**City of Portland, Maine - Building or Use Permit Application**  
 389 Congress Street, 04101 Tel: (207) 874-8703, Fax: (207) 874-8716

Permit No: 02-1235	Issue Date: DEC - 5 2002	CBL: 212 A058001
-----------------------	-----------------------------	---------------------

Past Use: Vacant	Proposed Use: Single Family / New 41' x 35' home with 24' x 28' two car attached garage.	Permit Fee: \$1,953.00	Cost of Work: \$265,000.00	CEO District: 3
Proposed Project Description: New 41' x 35' home with 24' x 28' two car attached garage.		FIRE DEPT: <input type="checkbox"/> Approved <input type="checkbox"/> Denied	INSPECTION: Use Group: R-3 Type: 50 2/4/02	
		Signature: [Signature]		Signature: [Signature]
PEDESTRIAN ACTIVITIES DISTRICT (P.A.D.)				
Action: <input type="checkbox"/> Approved <input type="checkbox"/> Approved w/Conditions <input type="checkbox"/> Denied				
Signature: _____ Date: _____

Proposed Use/Work - Construct New 35' x 42' single family with 24' x 28' 2 car garage

1ST FLOOR PLAN

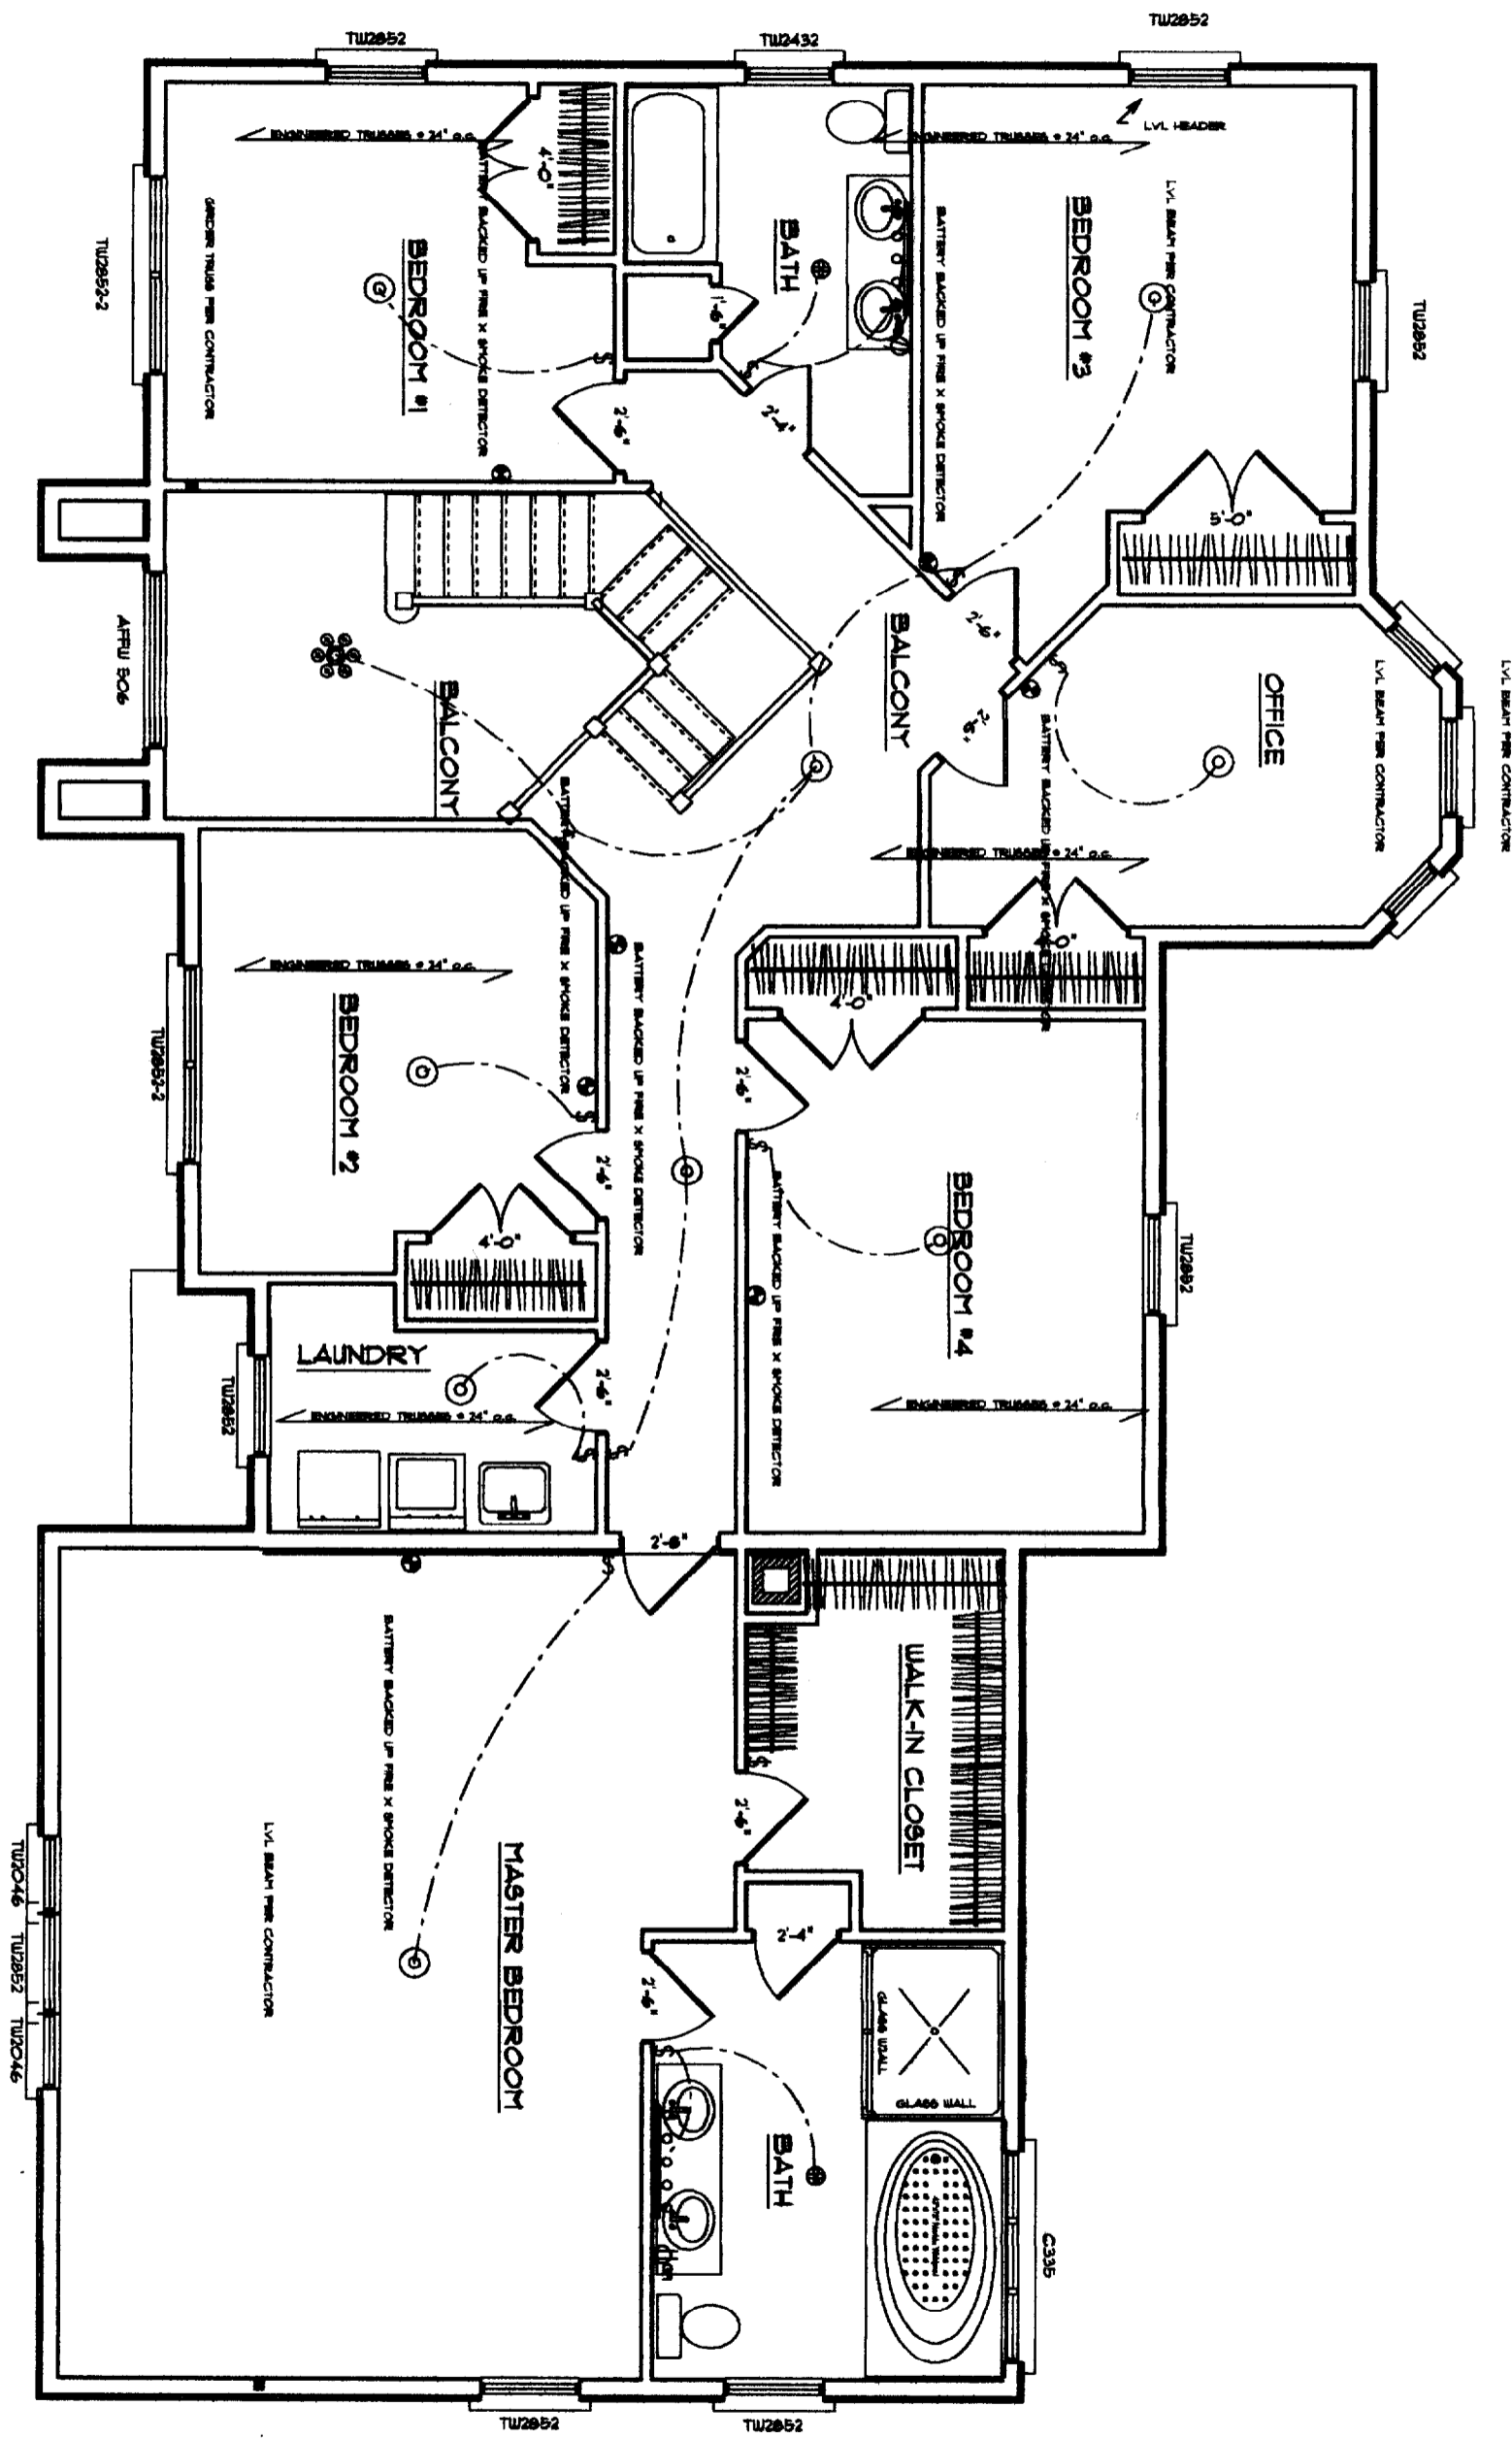
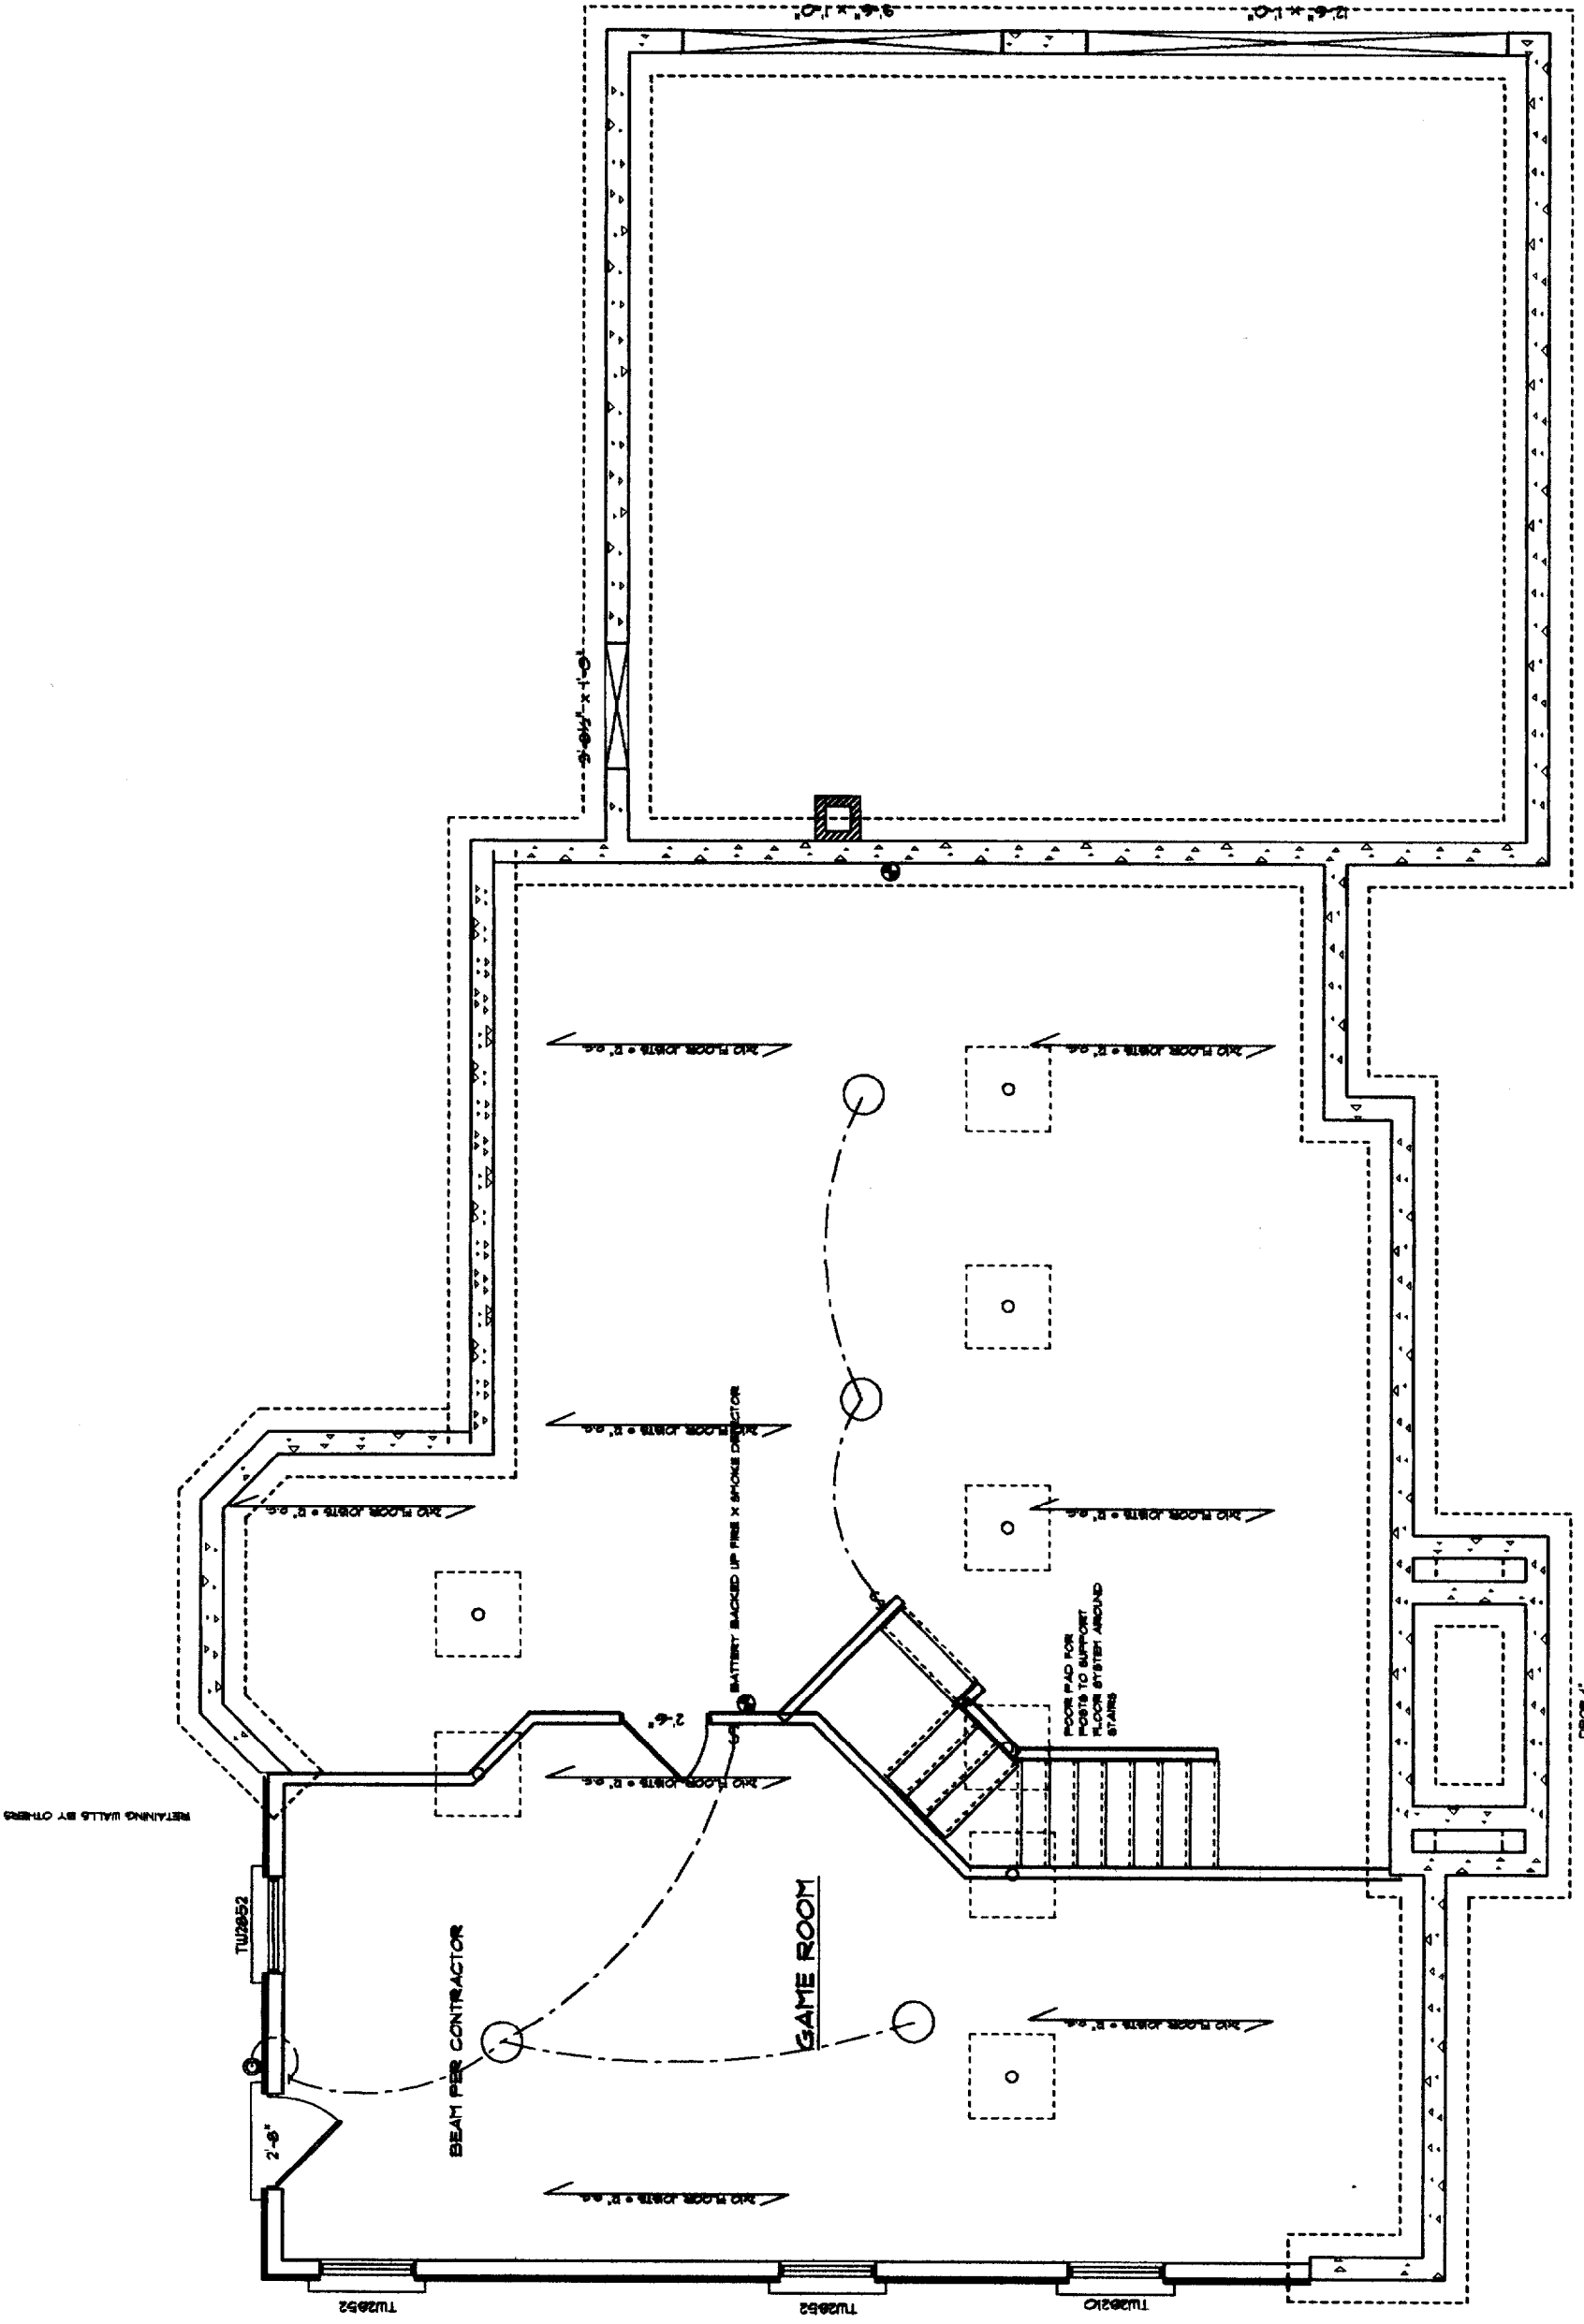
- 1) Basement stairs must be enclosed.
- 2) Winders must be no less than 6 inches at their narrowest point and at least 10 " (net tread ) at a distance 12 inches from the narrowest point.

SITE PLAN	
CLOUTIER CONSTRUCTION	
TIDE MILL ROAD	
PORTLAND, MAINE	
CLOUTIER CONSTRUCTION	
HERBERT P. GRAY	
111 SIMONS ROAD, SOUTH PORTLAND, MAINE 04106	
SCALE: 1"=20'	DWG. NO. 1
DATE: 10/24/02	
DRAWN BY: HPG	
CHECKED BY: HPG

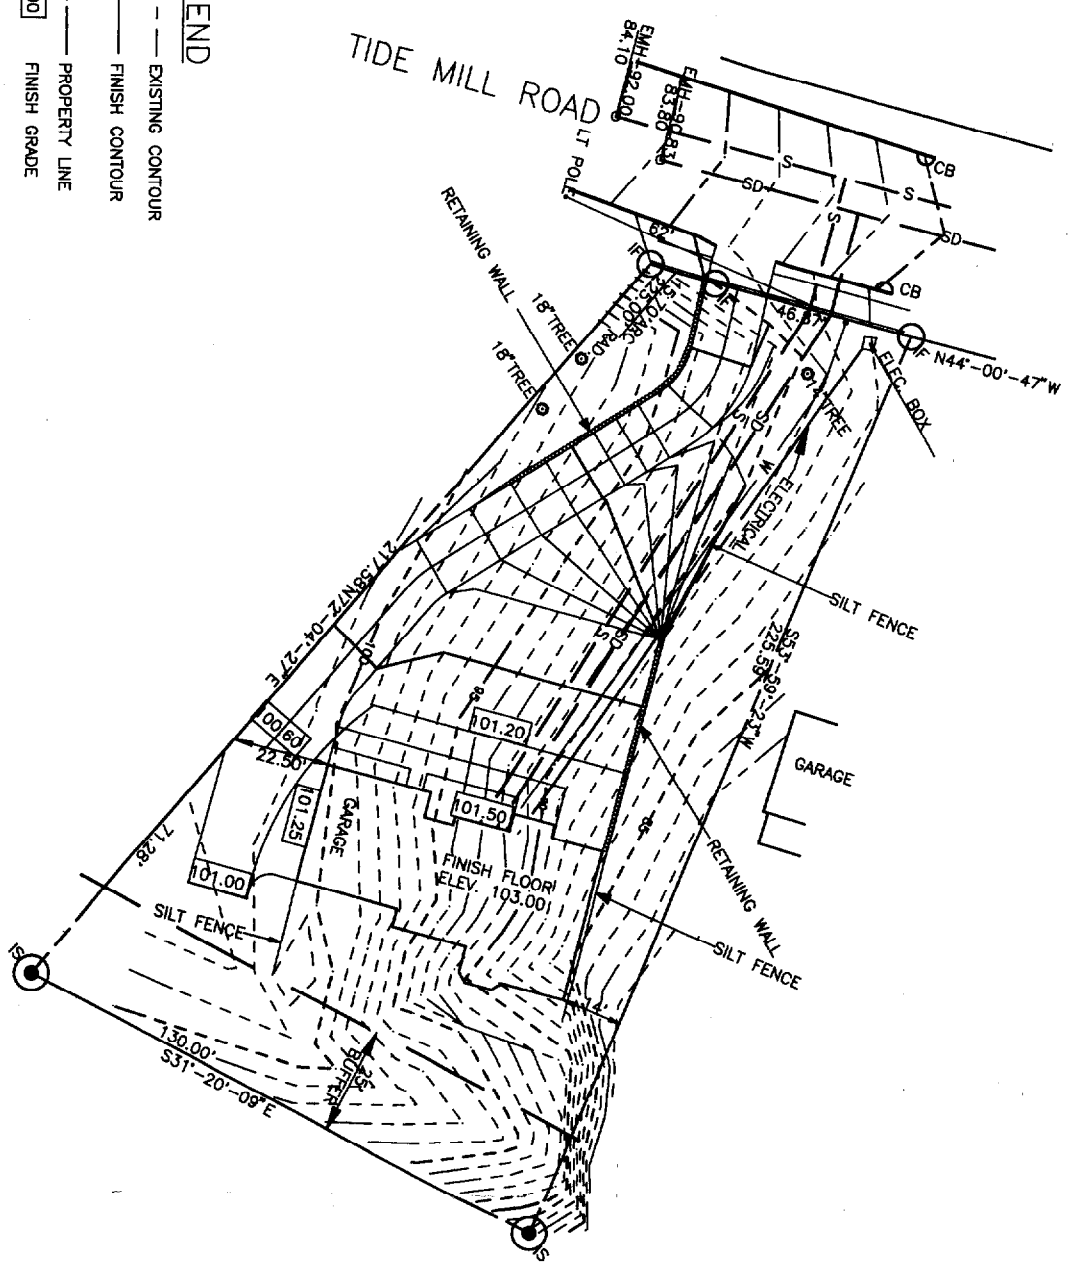
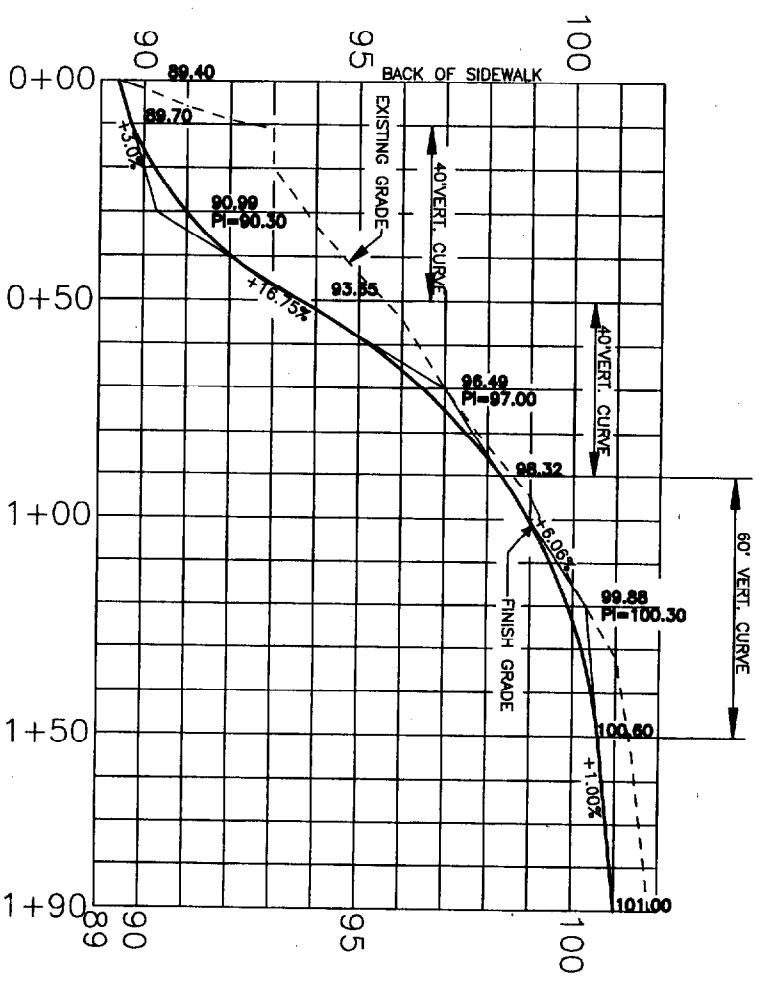
- 1 **GUARD RAILS WILL BE REQUIRED (PER BOCA CODE) ALONG THE THREE RETAINING WALLS.**
- 2 **CLEANOUTS MUST BE INSTALLED ON THE SANITARY AND STORM DRAIN LATERALS (PER CODE), WITHIN 80 FEET FROM THE MAIN LINES OF EACH UTILITY.**

- 9 **The site contractor shall establish finish grades at the foundation, bulkhead and basement windows to be in conformance with the first floor elevation (FFE) and sill elevation (SE) set by the building contractor to provide for positive drainage away from entire footprint of building.**
